Our Case Number: ABP-317560-23

Re: Proposed windfarm development including 13 no. wind turbines in Bunnyconnellan, Co. Mayo and hydrogen plant in Castleconnor, Co. Sligo.
Carrowleagh, Bunnyconnellan, Co. Mayo and Curraun, Castleconnor, Co. Sligo.

RE:. Case number 317560-23
Bartholomew & Jackie Morrisroe

Title
Proposed Firlough Wind Farm
Site Layout & Existing
Carrowleagh Wind Farm Site
Location Plan, Sheet 2 of 2

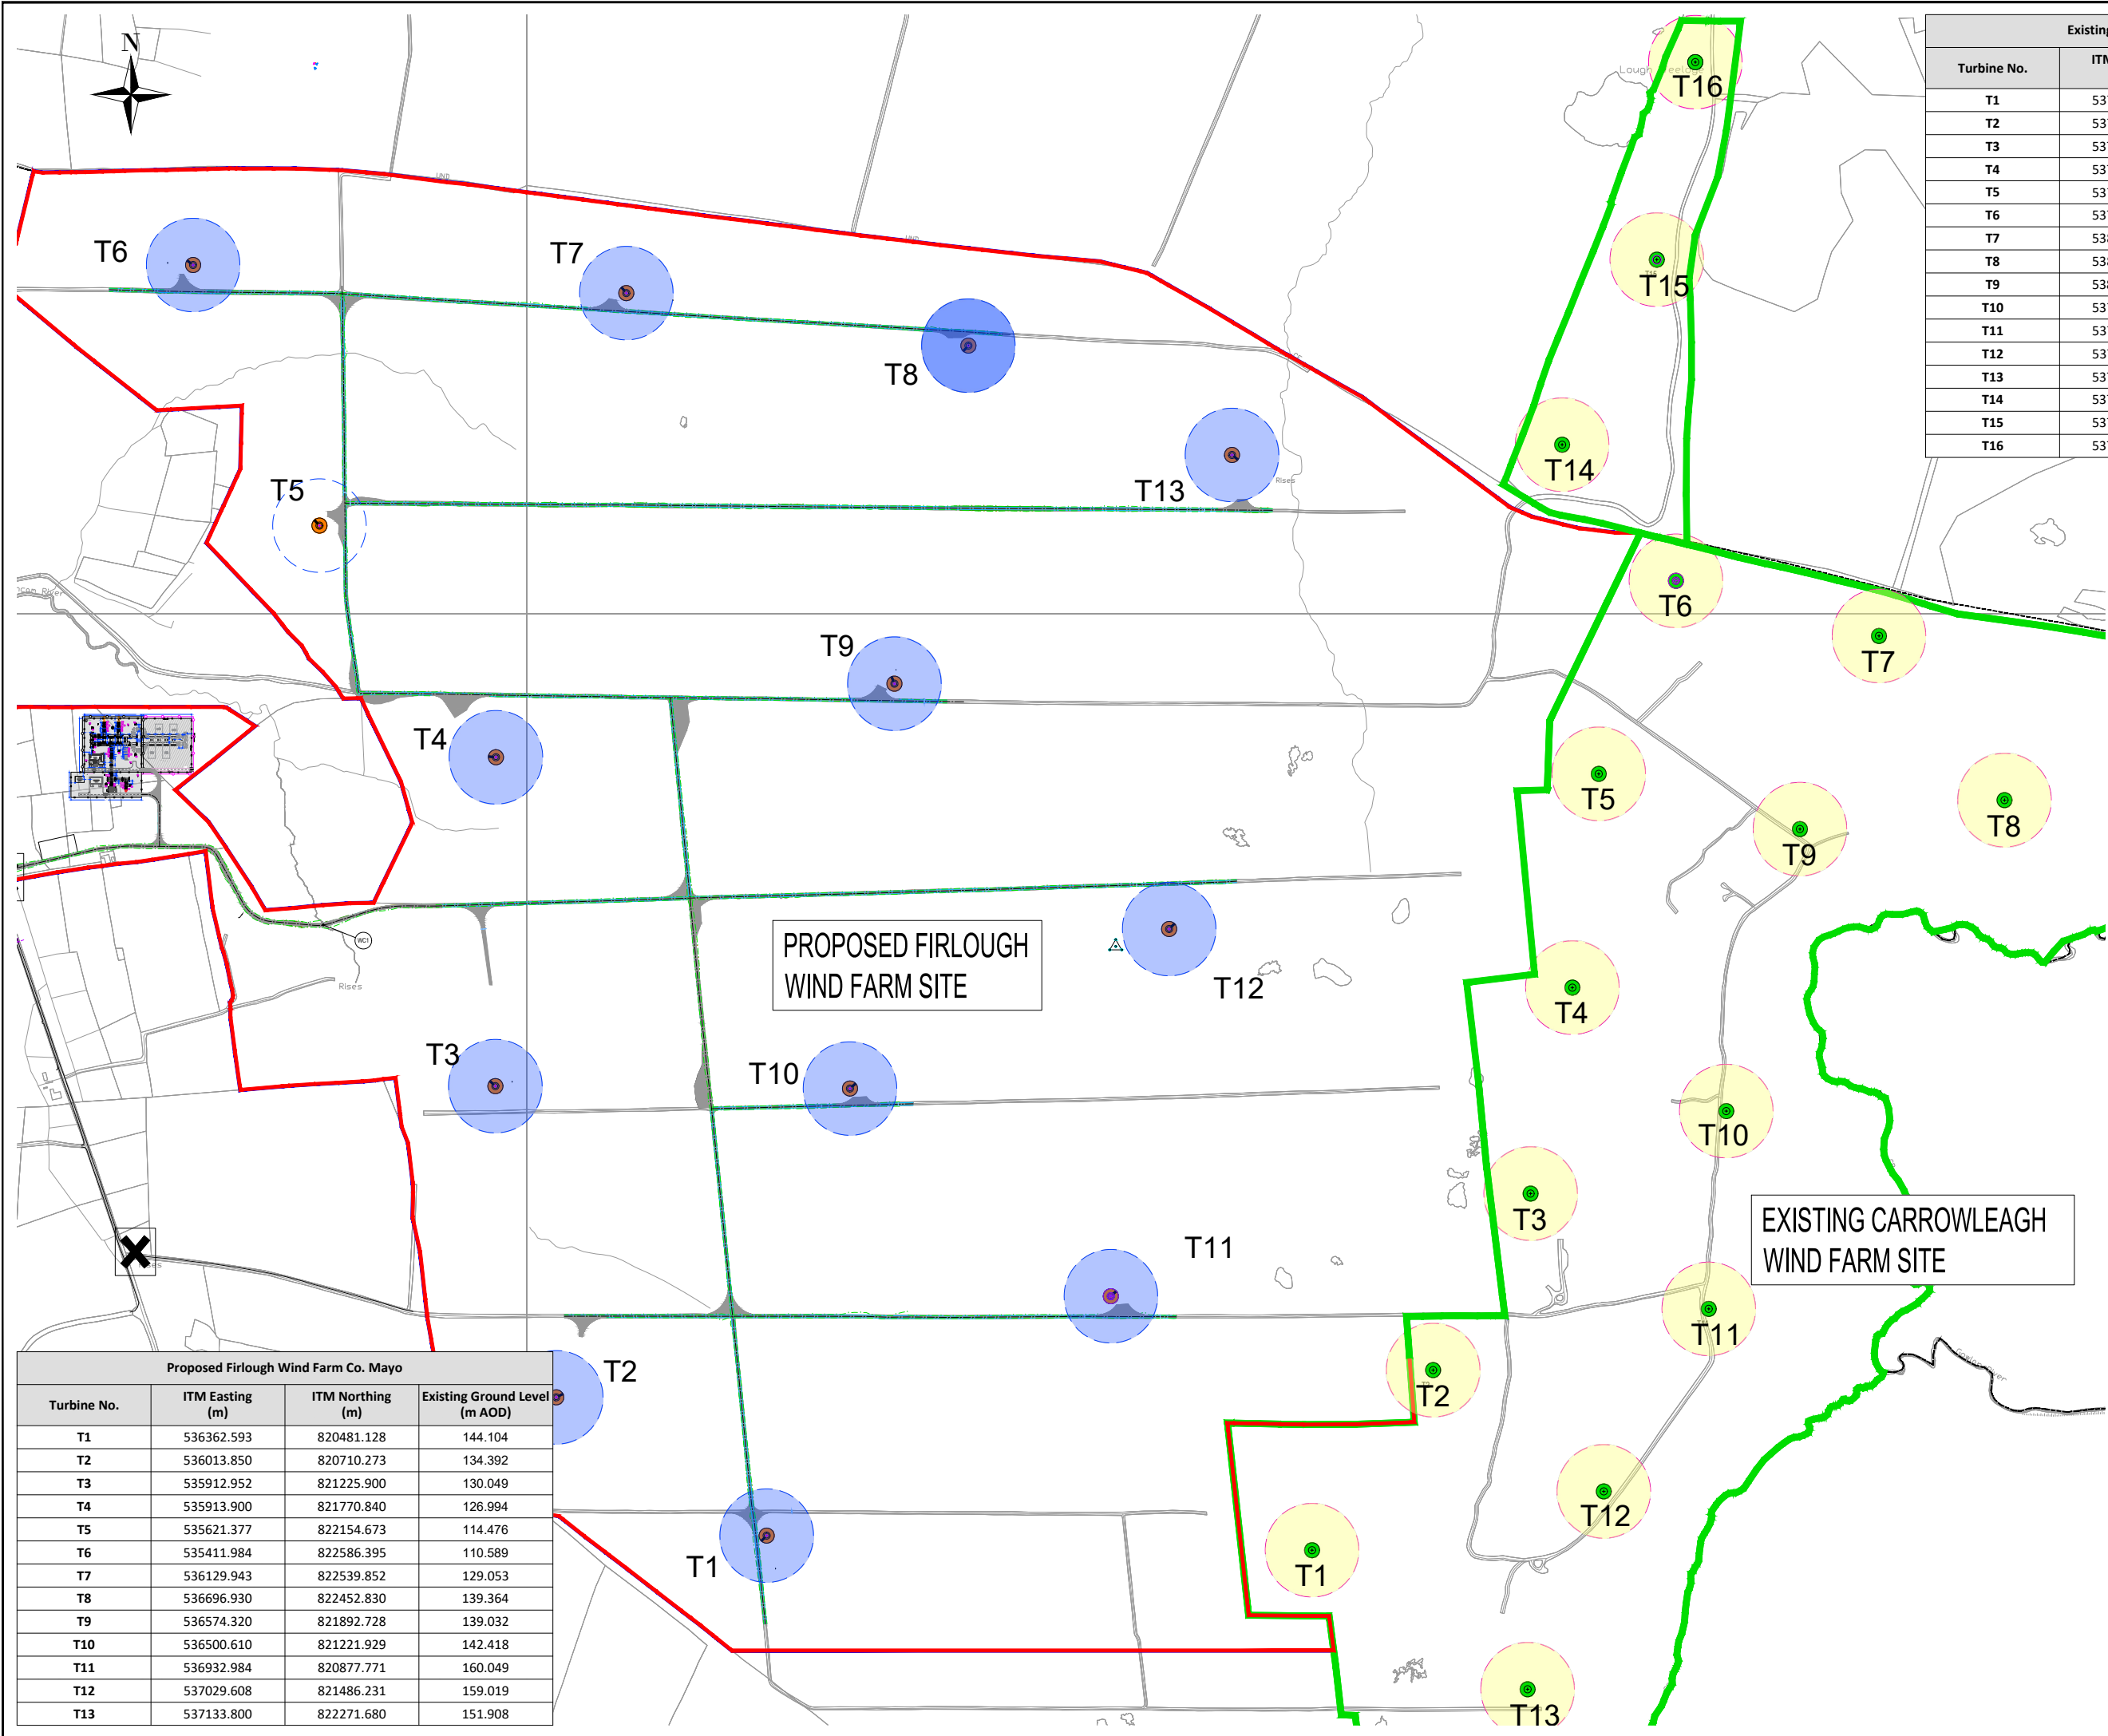
Concern: - It is difficult to understand what is meant by the above paragraph when it is read in conjunction with the below Wind farm Site Layout. Why is there no mention of T5? We seek clarification of this.
